10 May 2017

**Re: Western Sydney Stadium - Response to Stage 2 DA Comments
Attachment One – detailed Comments
'Integration of Services'**

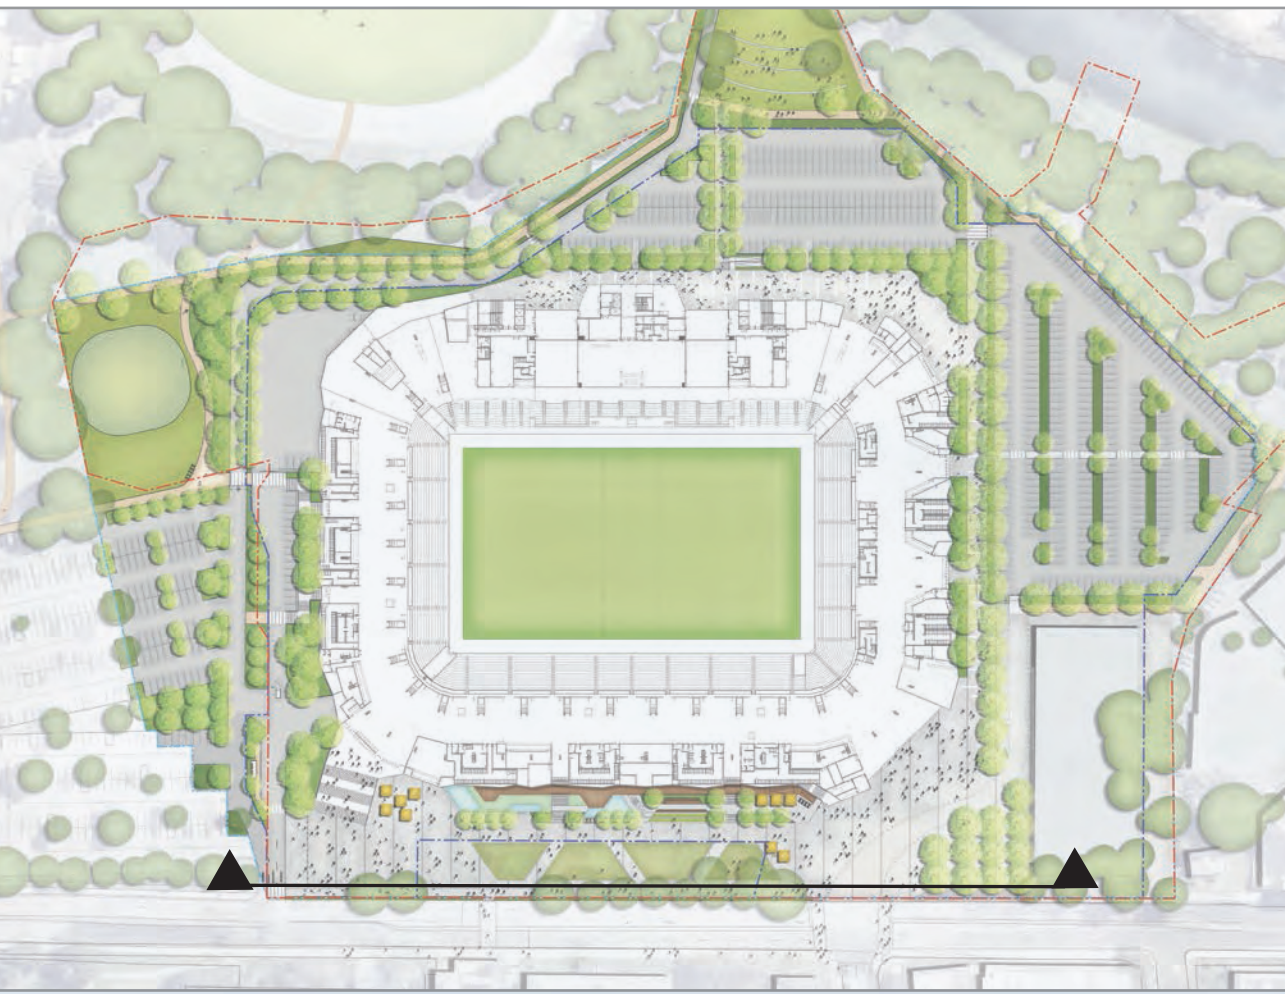
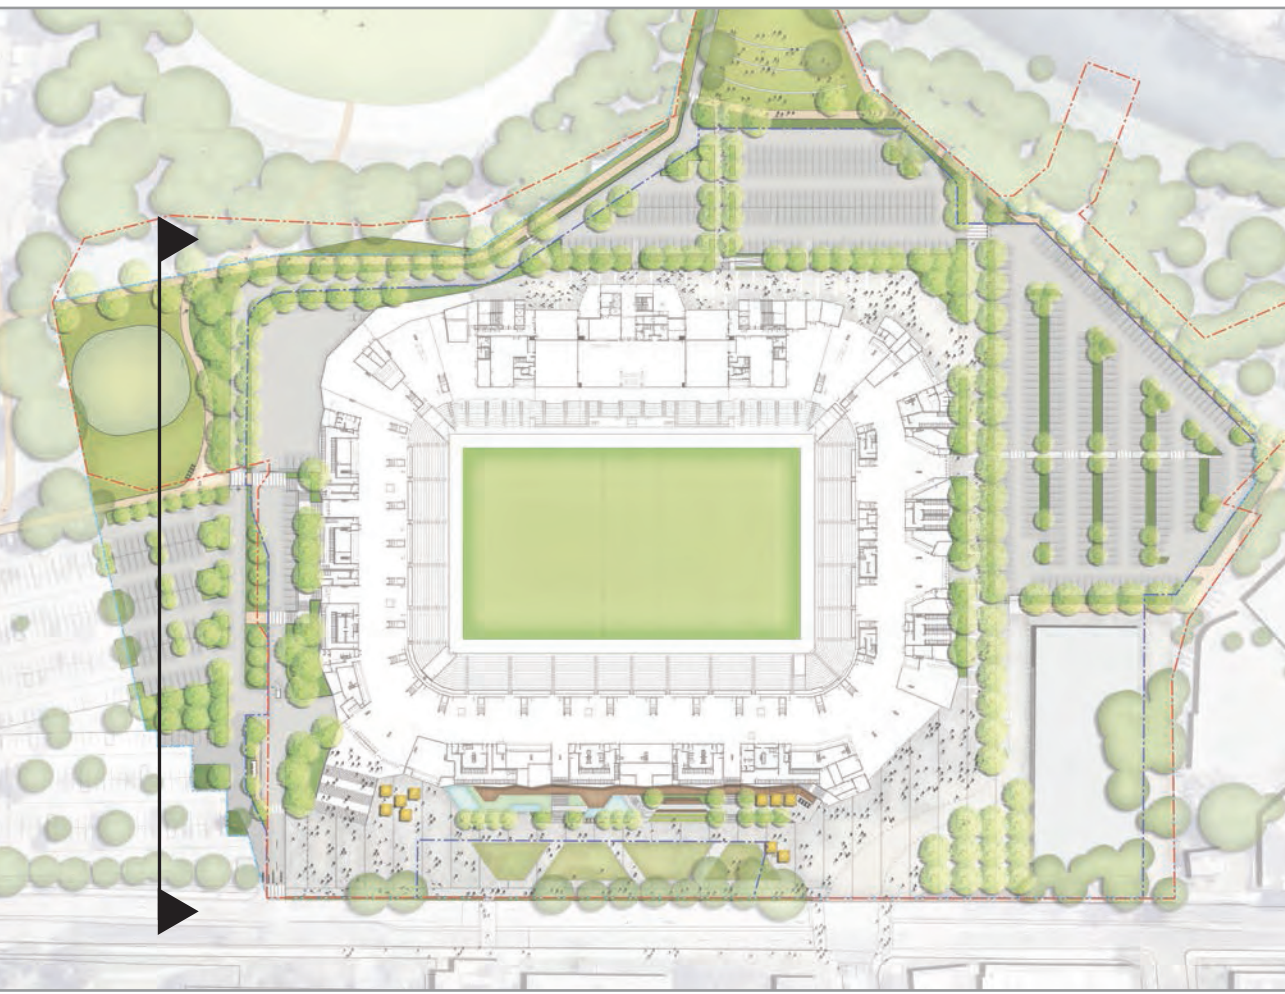
The Service access road separates Parklands, Kings Oval and the southern car park from the southern entry and O'Connell Place. Council is concerned that there is no dedicated and direct pedestrian access route and that one must traverse the southern car park. The service turnaround area uses valuable space that could otherwise be used to achieve the Guidelines aim for 'continuous curtilage' for pedestrian circulation around stadium. Furthermore, access to the western car park is via both the northern car parking and the southern car parking and stadium service. It is unclear how much of the site and car parking will be fenced preventing public access at all times.

· The design be revised to better integrate the loading dock/service area under the southern end of the stadium to lessen the impact on parklands and pedestrian circulation opportunities; and

A dedicated East-West pedestrian link has been included to the south of the stadium. This sits in a wide median which includes a combination of planted and grassed understory with shade trees along its length. This walkway will also include appropriate pedestrian lighting. This walkway will provide a strong link to O'Connell Street, O'Connell Place and the parklands to the south and west of the site.

The southern access roads to the loading dock and Western Carpark / Old Kings Oval have been grouped to form a single access road, allowing more space for pedestrians and to enhance the 'parkland' experience of this part of the site.
